Title:  
Figure 16.4 BESS Fire Emissions Study Area,  
Receptors and Modelled BESS Locations

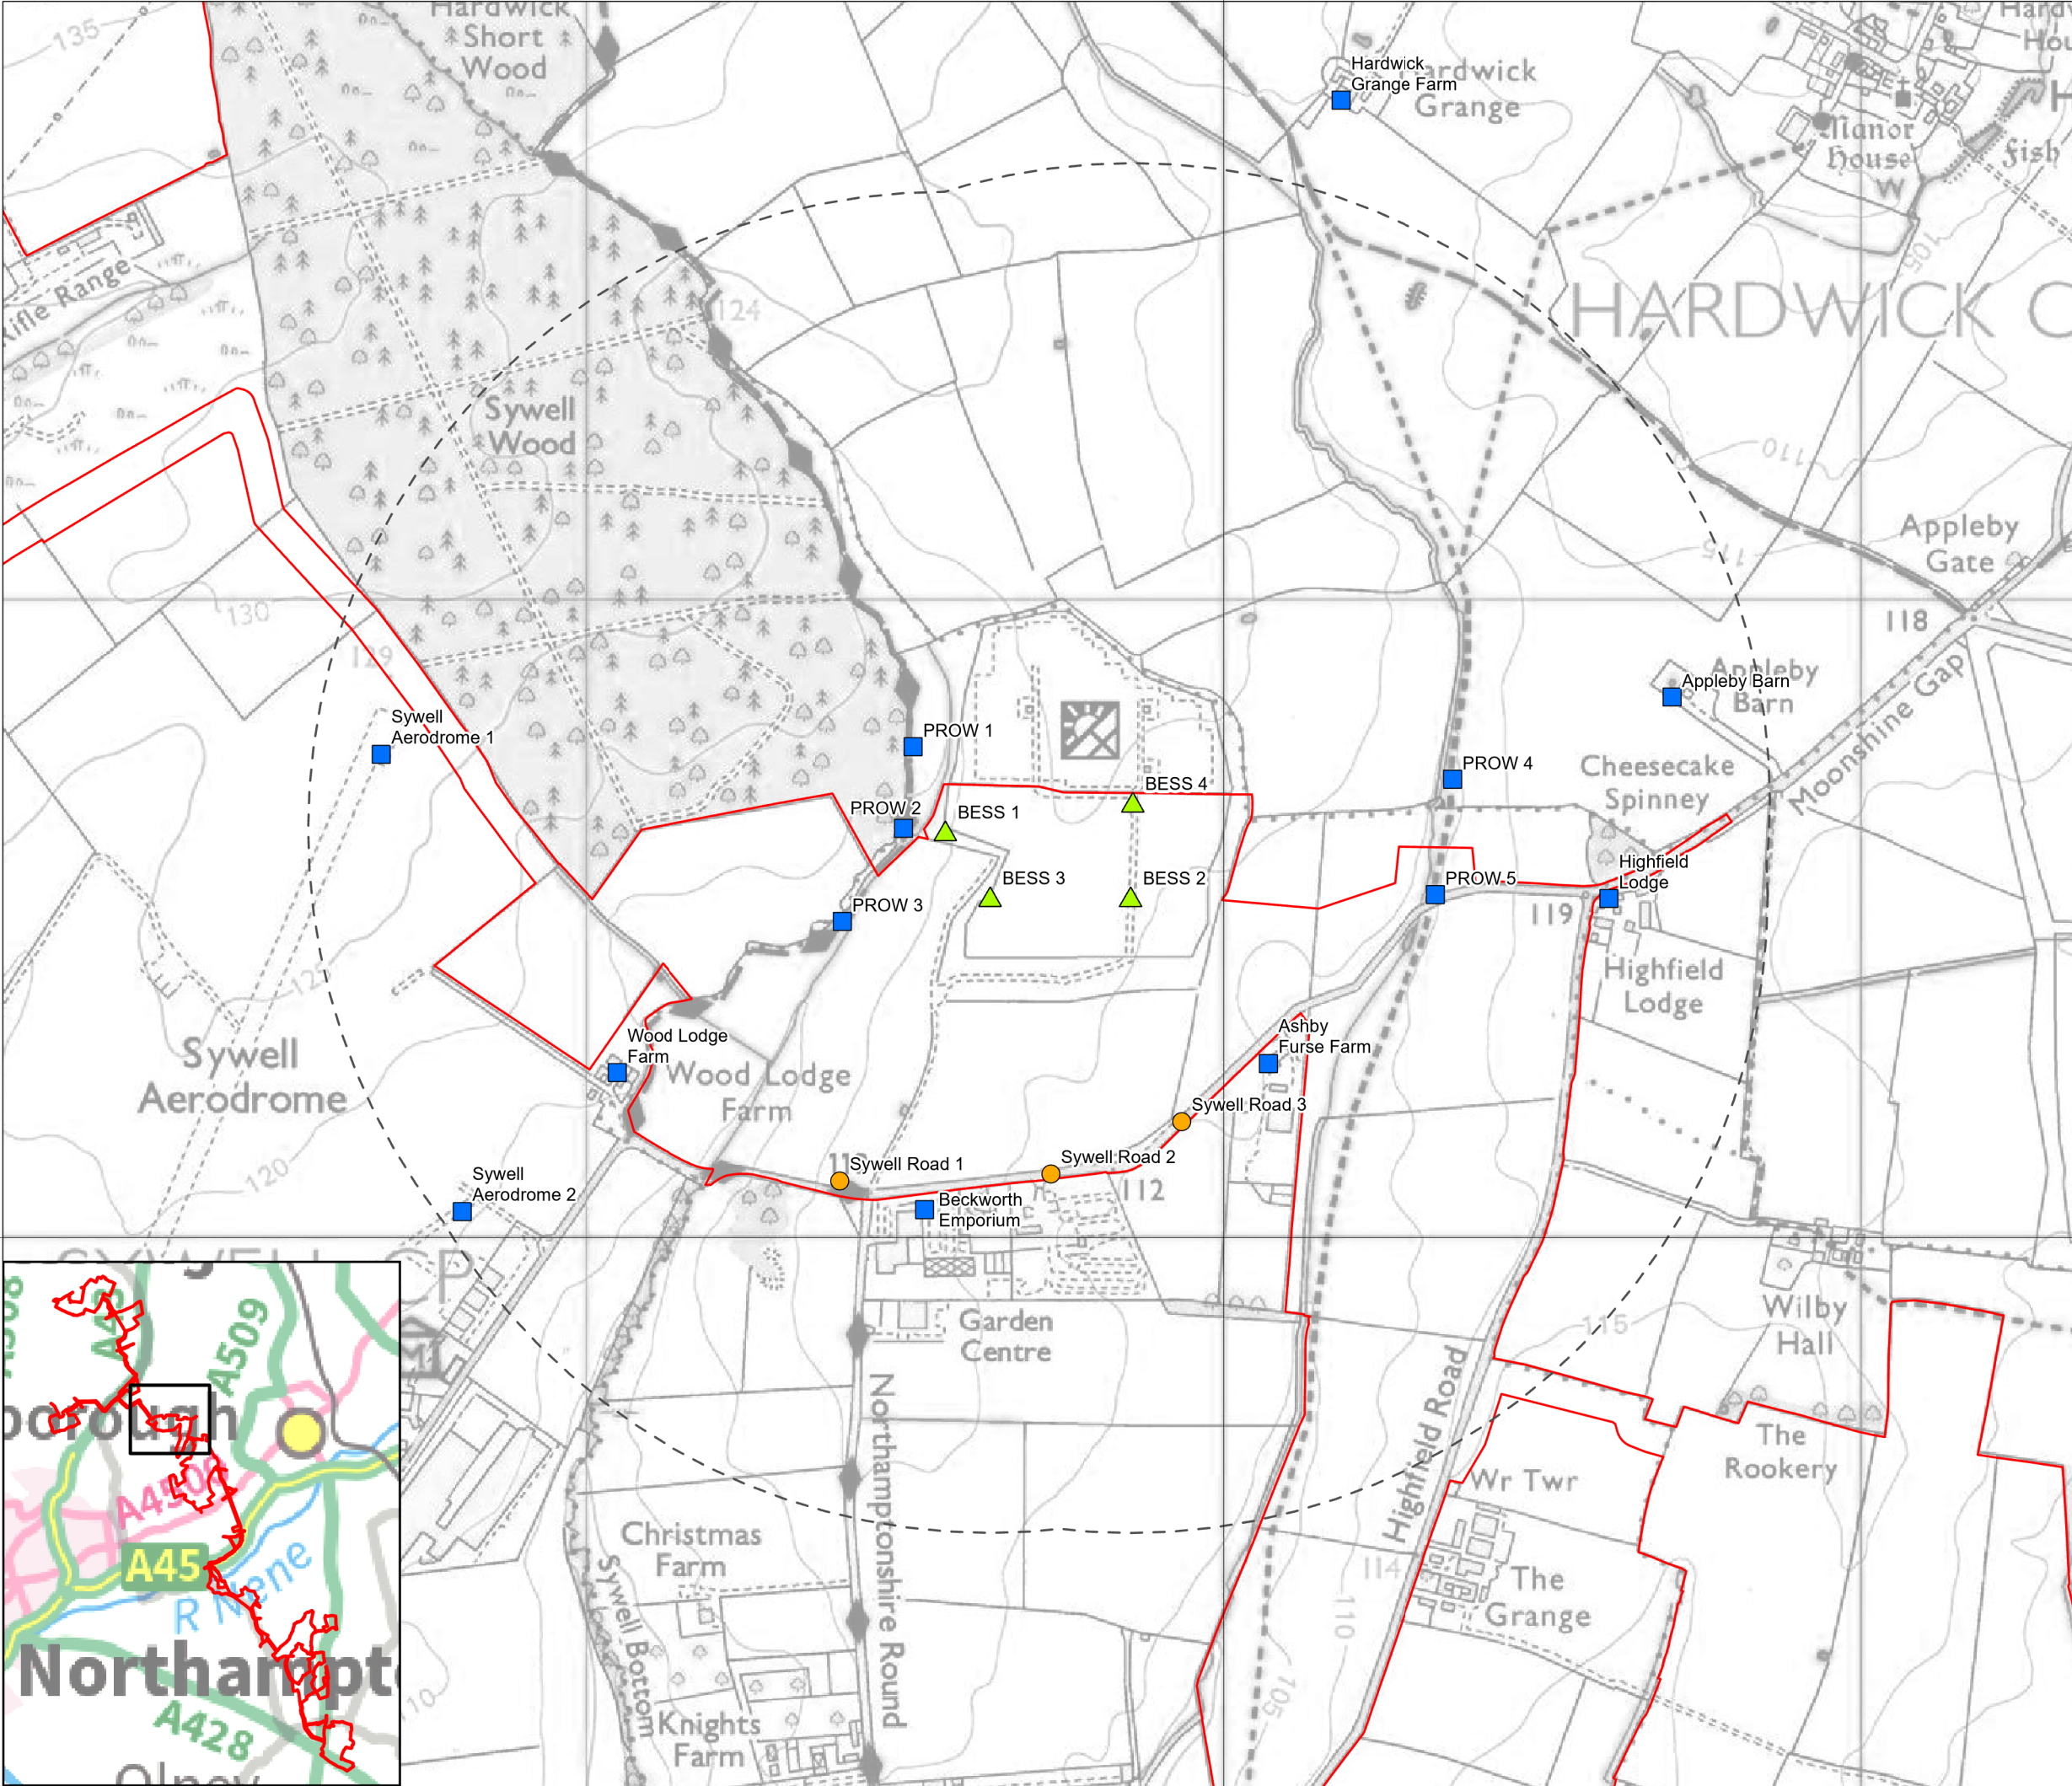
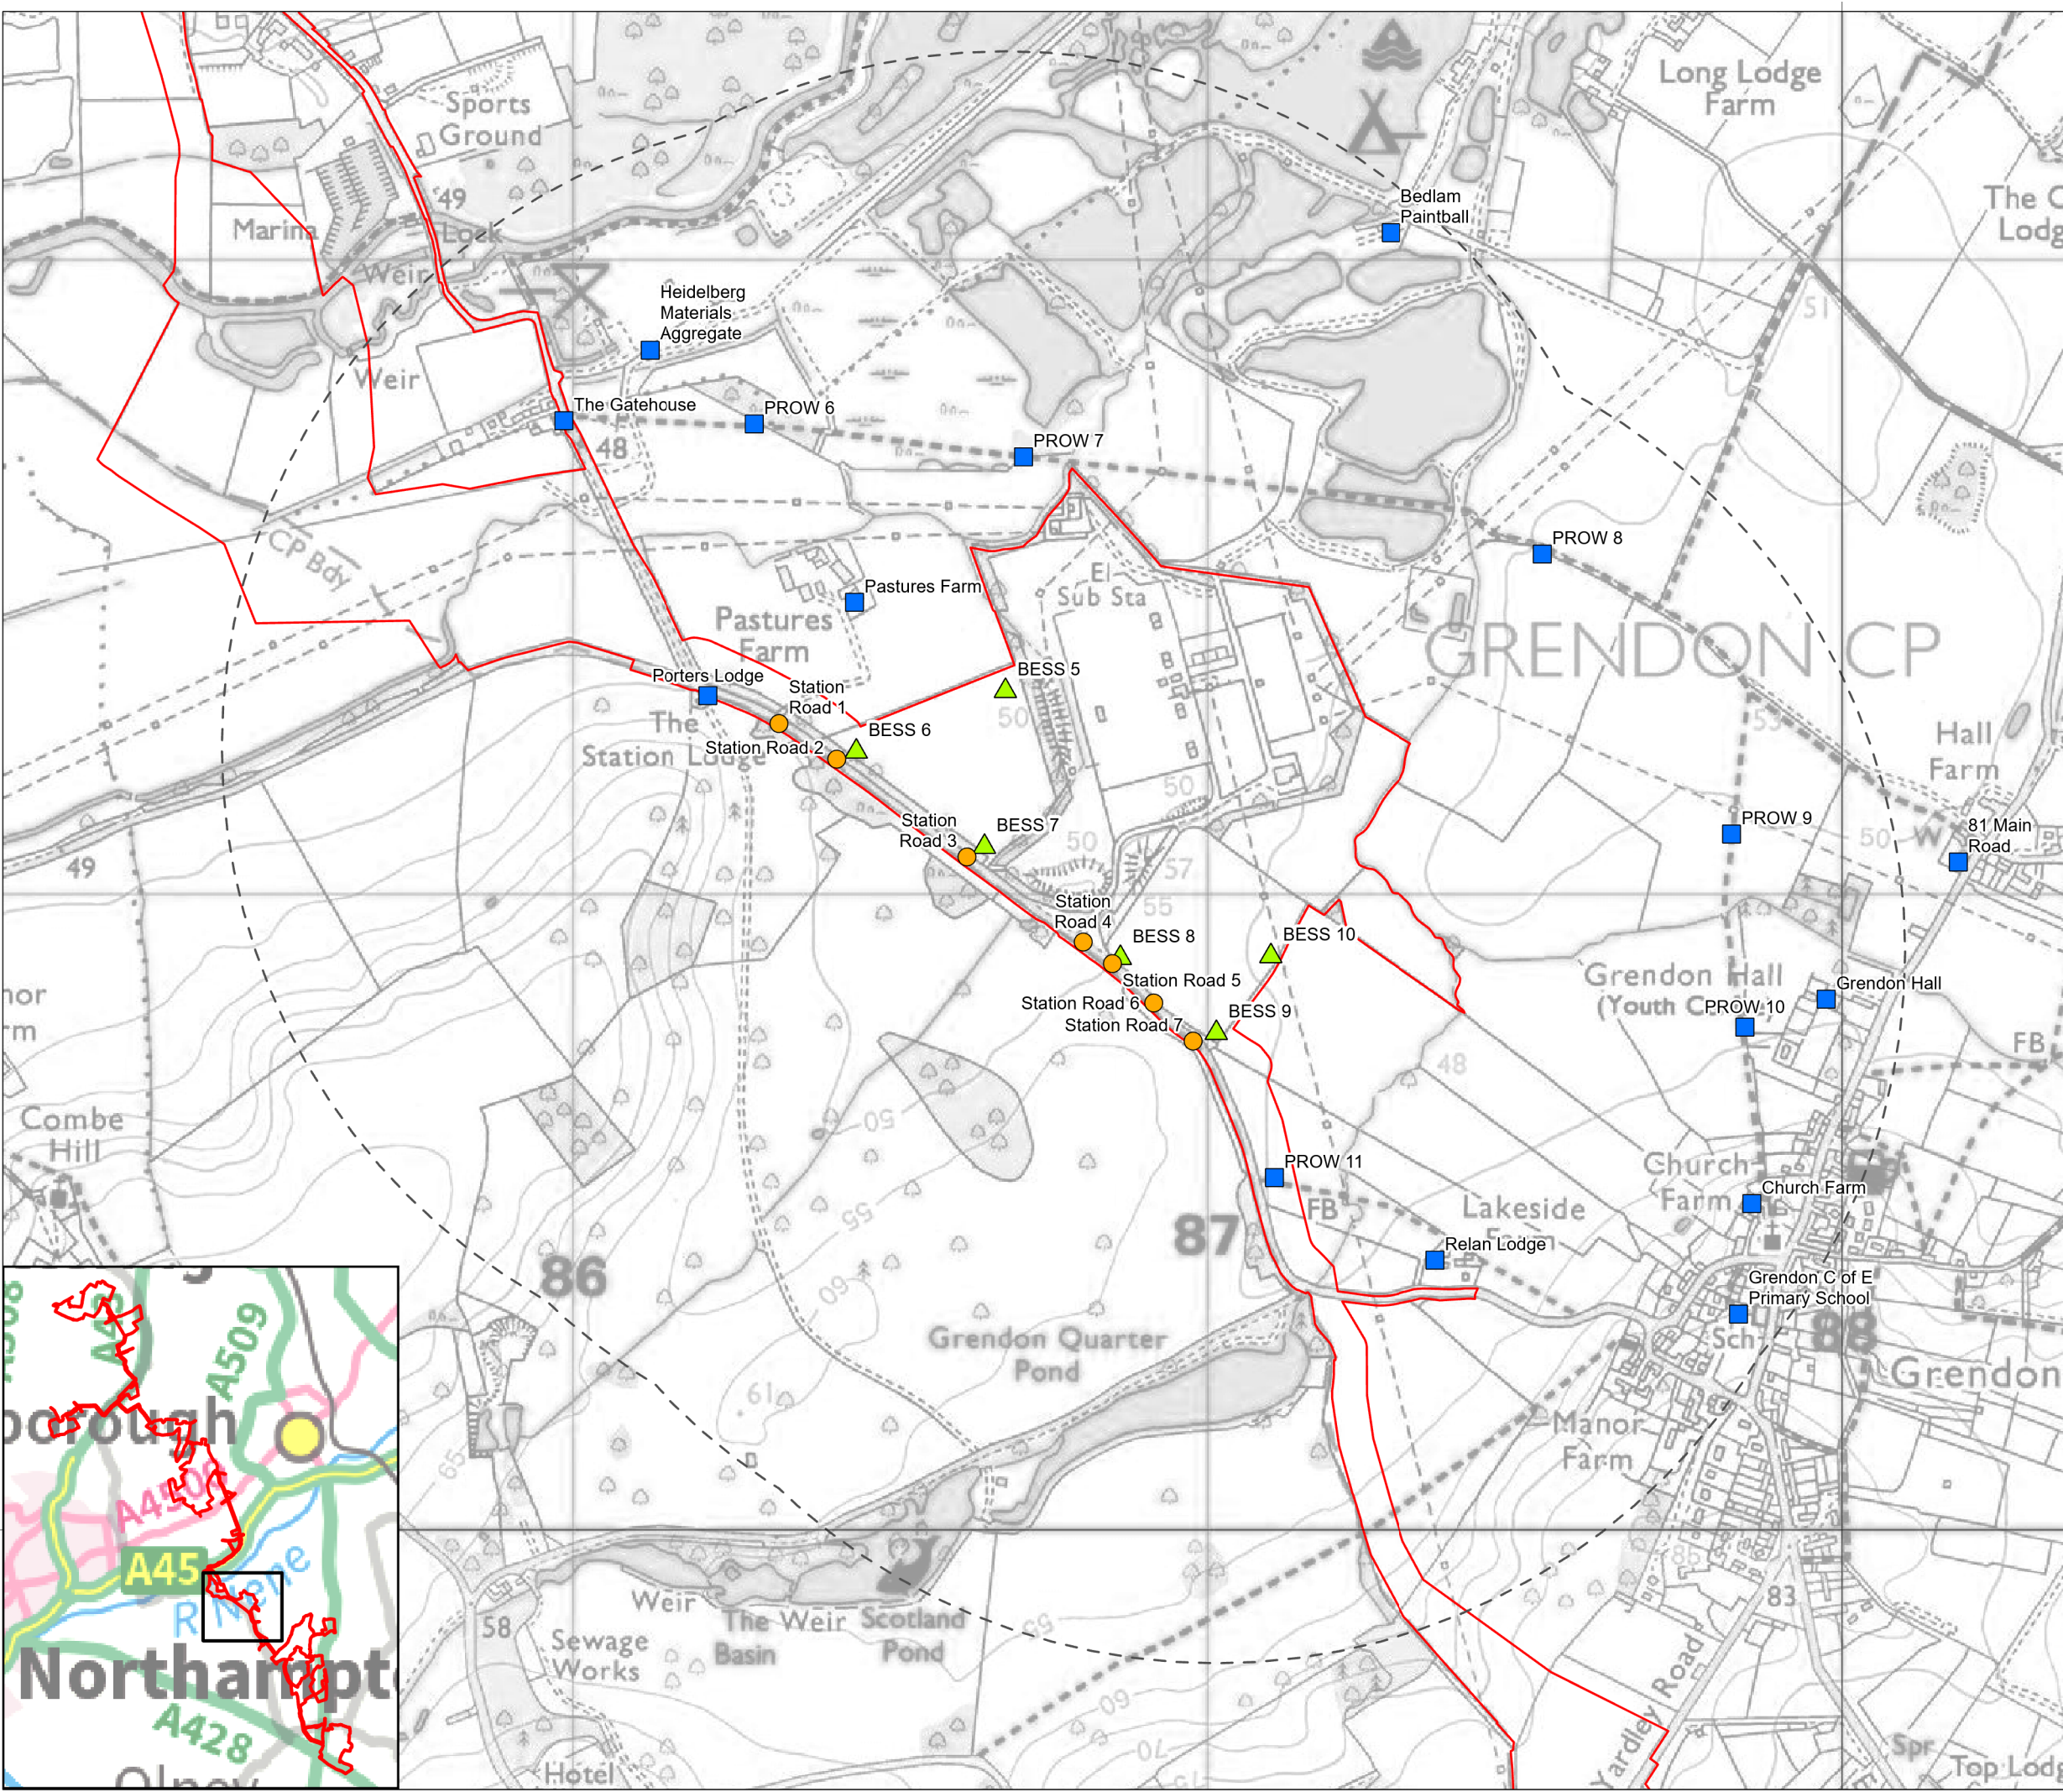
The Applicant's statement that an Emergency Response Plan (ERP) will be developed post consent following NFCC and NFPA 855 guidance does not demonstrate adequacy.

Remote operation of a BESS site has repeatedly been identified as a factor delaying the emergency response to a BESS fire and hindering firefighting efforts. Despite this, the Outline Battery Storage Safety Management Plan (Revision A) still relies on remote operation as it states the BESS is anticipated to have '24/7 remote monitoring of the system via a dedicated control facility. The control facility will have the capability to shut the system down should the need arise and will also be responsible for implementing the emergency plan and acting as a point of contact for the emergency services'.

This shows the applicant has failed to address the documented real world issue of delayed response with remote operation and leaves a critical gap in safety and emergency planning.
